EL PASO COUNTY STORMWATER MANAGEMENT PLAN CHECKLIST

PPR-22-059

SHEET IDENTIFICATION EC2

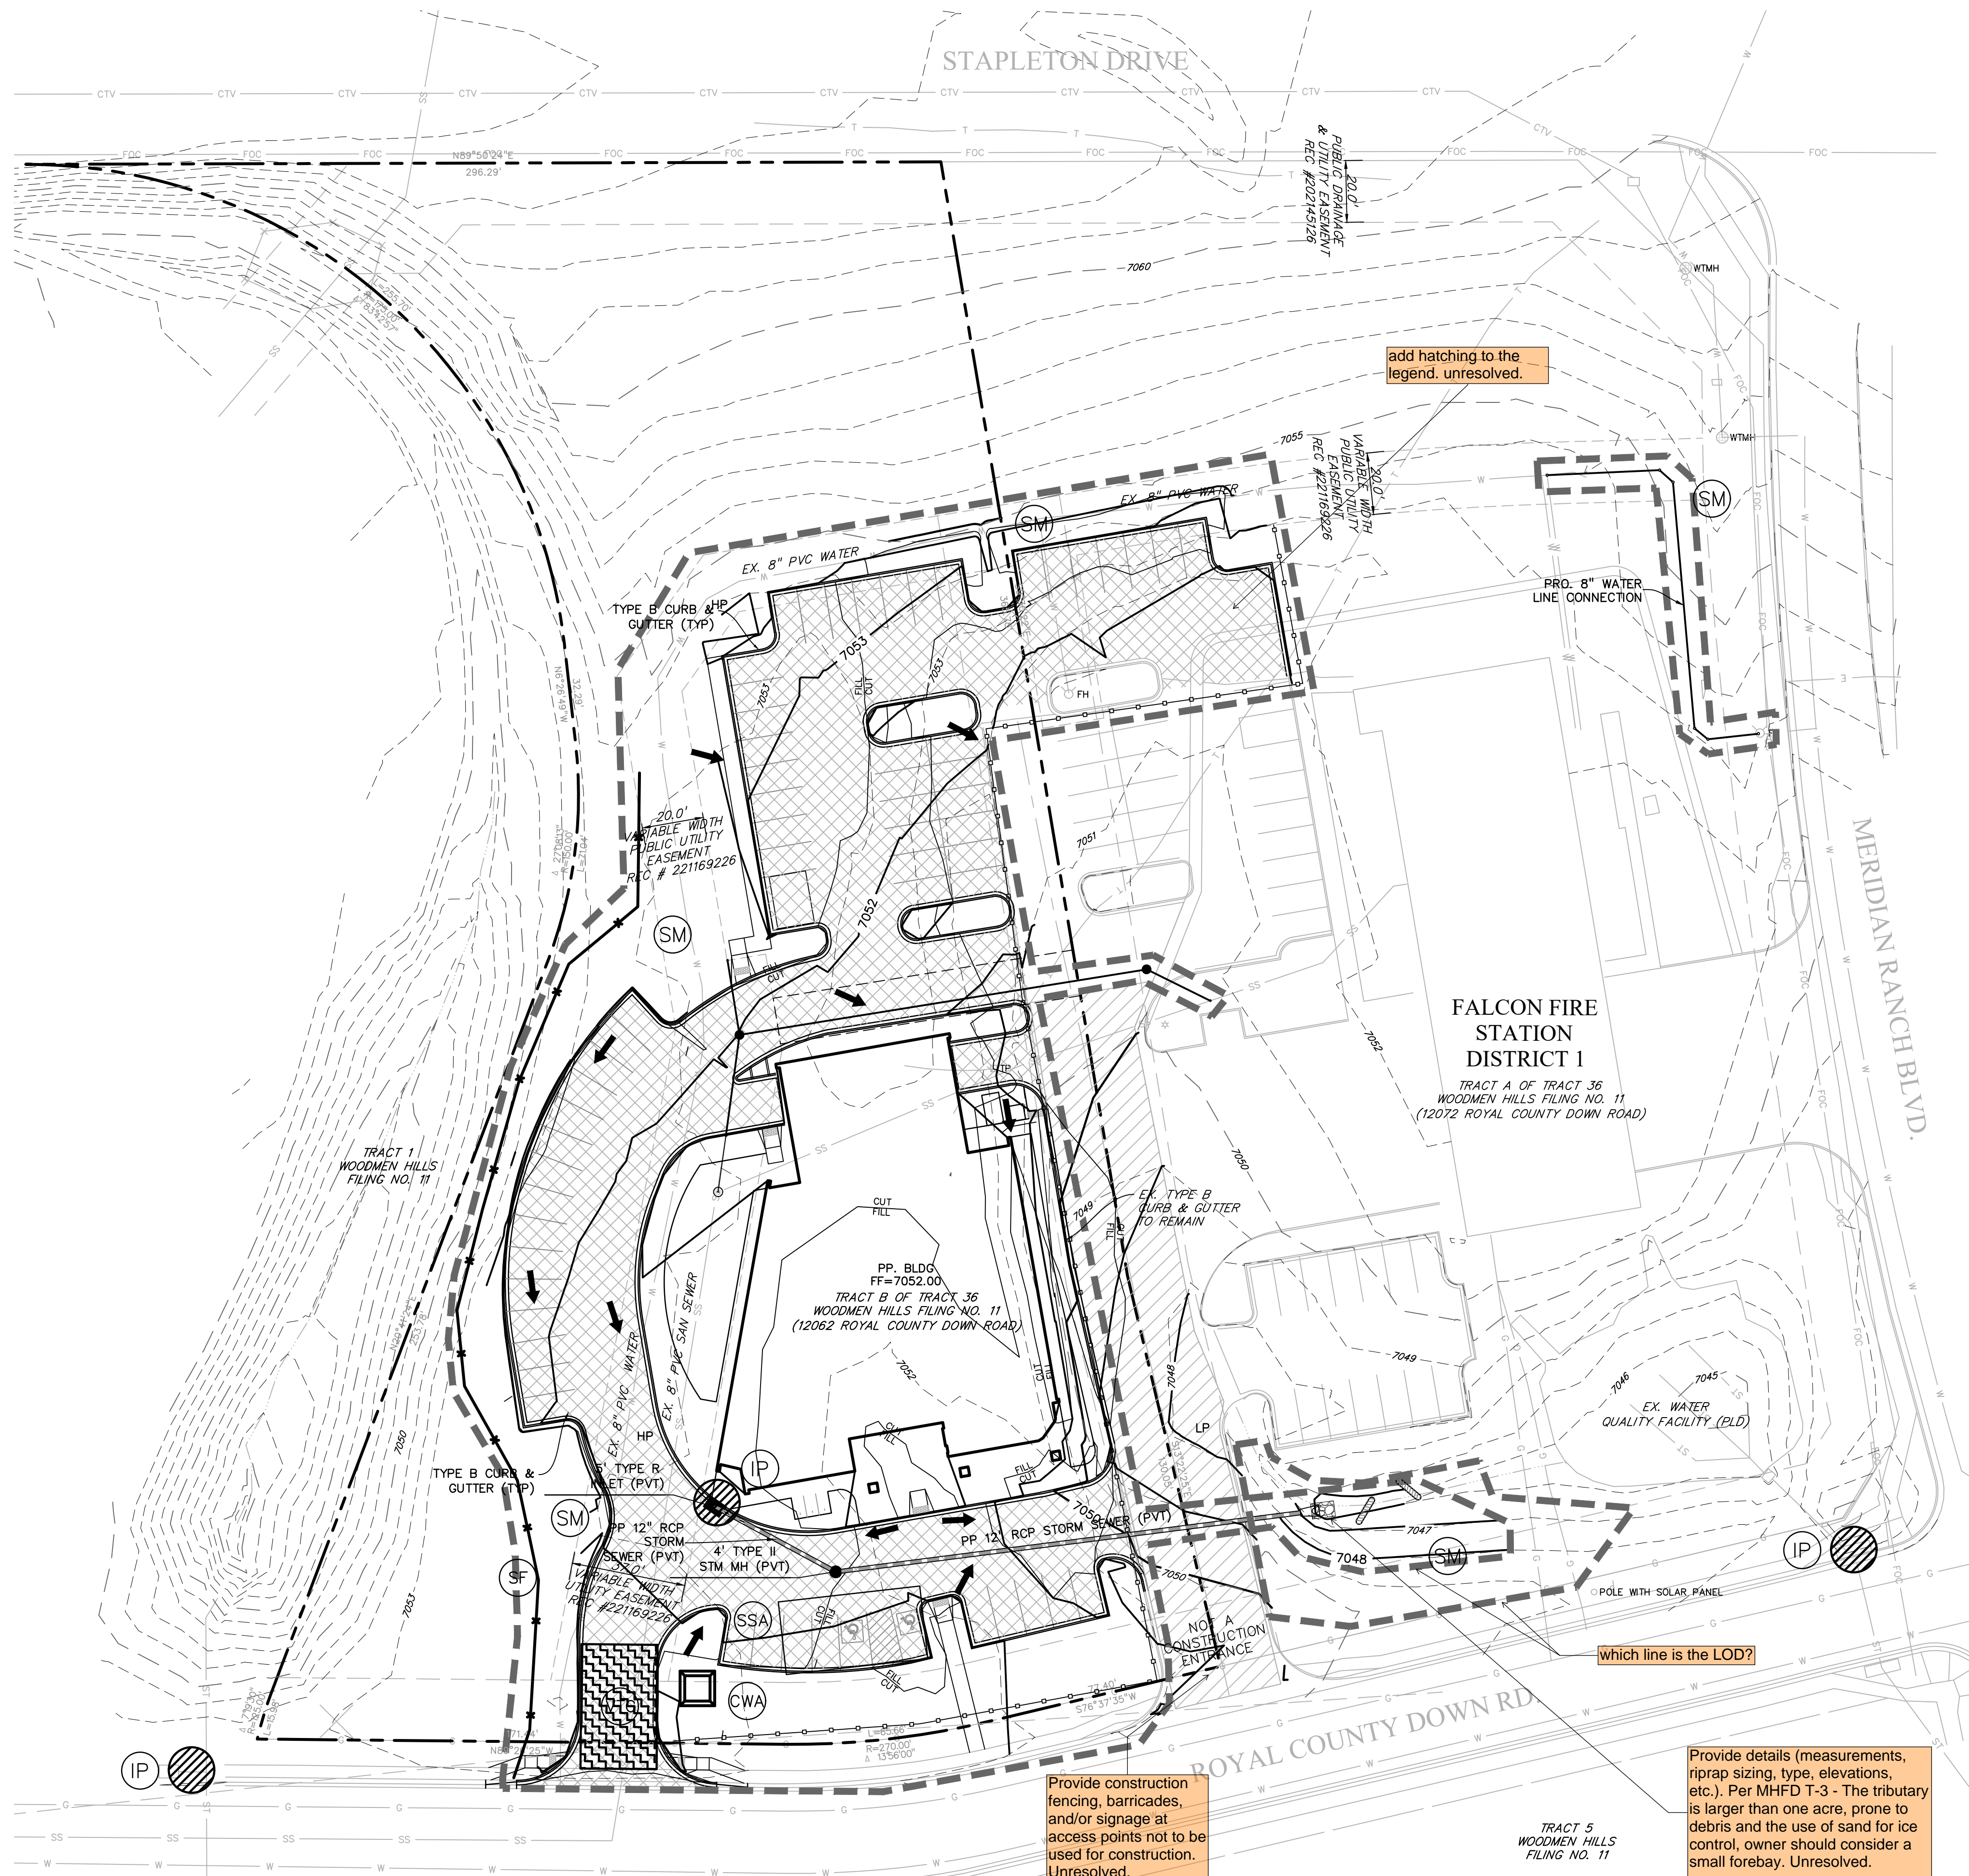
7	Estimates of the total site area and area to undergo disturbance; current area of disturbance must be updated on the SWMP as changes occur		✗
8	Soil erosion potential and impacts on discharge that includes a summary of the data used to determine soil erosion potential		✓
9	A description of existing vegetation at the site and percent ground cover and method used to determine ground cover		✓
10	Location and description of all potential pollution sources including but not limited to: disturbed and stored soils; vehicle tracking; management of contaminated soils; loading and unloading operations; outdoor storage of materials; vehicle and equipment maintenance and fueling; significant dust generating process; routine maintenance activities involving fertilizers, pesticides, herbicides, detergents, fuels, solvents, oils, etc.; on-site waste management; concrete truck/equipment washing; dedicated asphalt, concrete batch plants and masonry mixing stations; non-industrial waste such as trash and portable toilets		✓

Applicant	EPC
17	SWMP Map to include:		
17a	construction site boundaries		✓
17b	flow arrows to depict stormwater flow directions		✗
17c	all areas of disturbance		✓
17d	areas of cut and fill		✓
17e	areas used for storage of building materials, soils (stockpiles) or wastes		✓
17f	location of any dedicated asphalt / concrete batch plants		✗
17g	location of all structural control measures		✗
17h	location of all non-structural control measures		✓
17i	springs, streams, wetlands and other surface waters, including areas that require maintenance of pre-existing vegetation within 50 feet of a receiving water		✓
18	Narrative description of all structural control measures to be used. Modifications to EPC standard control measures must meet or exceed County-approved details		✓
19	Description of all non-structural control measures to be used including seeding, mulching, protection of existing vegetation, site watering, sod placement, etc.		✓

VTC-1. AGGREGATE VEHICLE TRACKING CONTROL

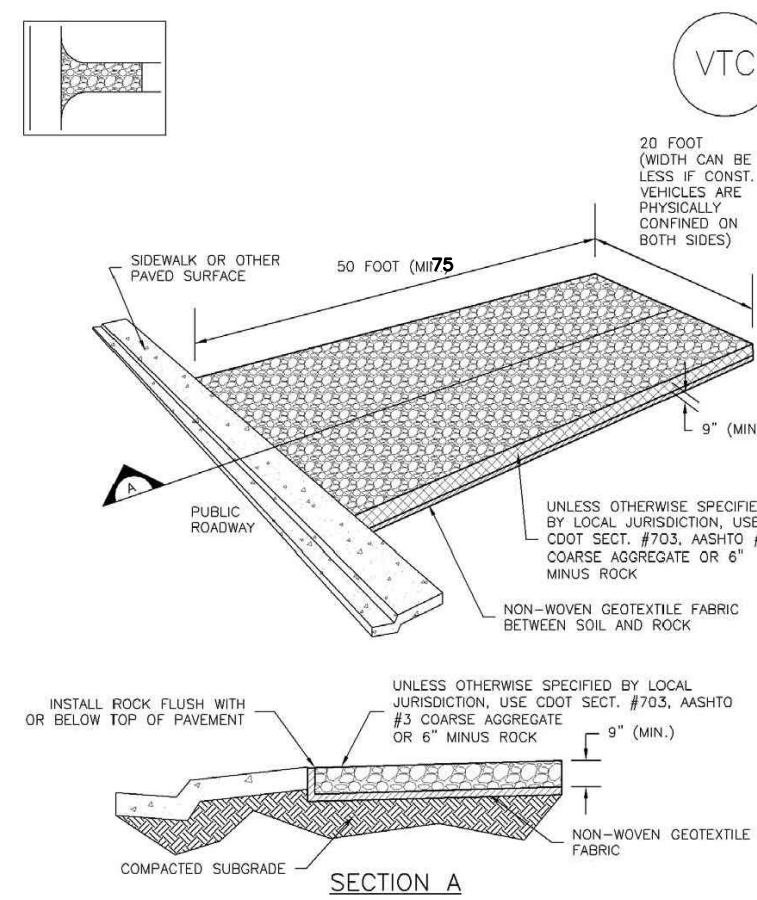
20	Technical drawing details for all control measure installation and maintenance; custom or other jurisdiction's details used must meet or exceed EPC standards		✗
21	Procedure describing how the SWMP is to be revised		✓
22	Description of Final Stabilization and Long-term Stormwater Quality (describe nonstructural and structural measures to control SW pollutants after construction operations have been completed, including detention, water quality control measure etc.)		✓
23	Specification that final vegetative cover density is to be 70% of pre-disturbed levels		✓
24	Outline of permit holder inspection procedures to install, maintain, and effectively operate control measures to manage erosion and sediment		✓
25	Record keeping procedures identified to include signature on inspection logs and location of SWMP records on-site		✓
26	If this project relies on control measures owned or operated by another entity, a documented agreement must be included in the SWMP that identifies location, installation and design specifications, and maintenance requirements and responsibility of the control measure(s)		✗
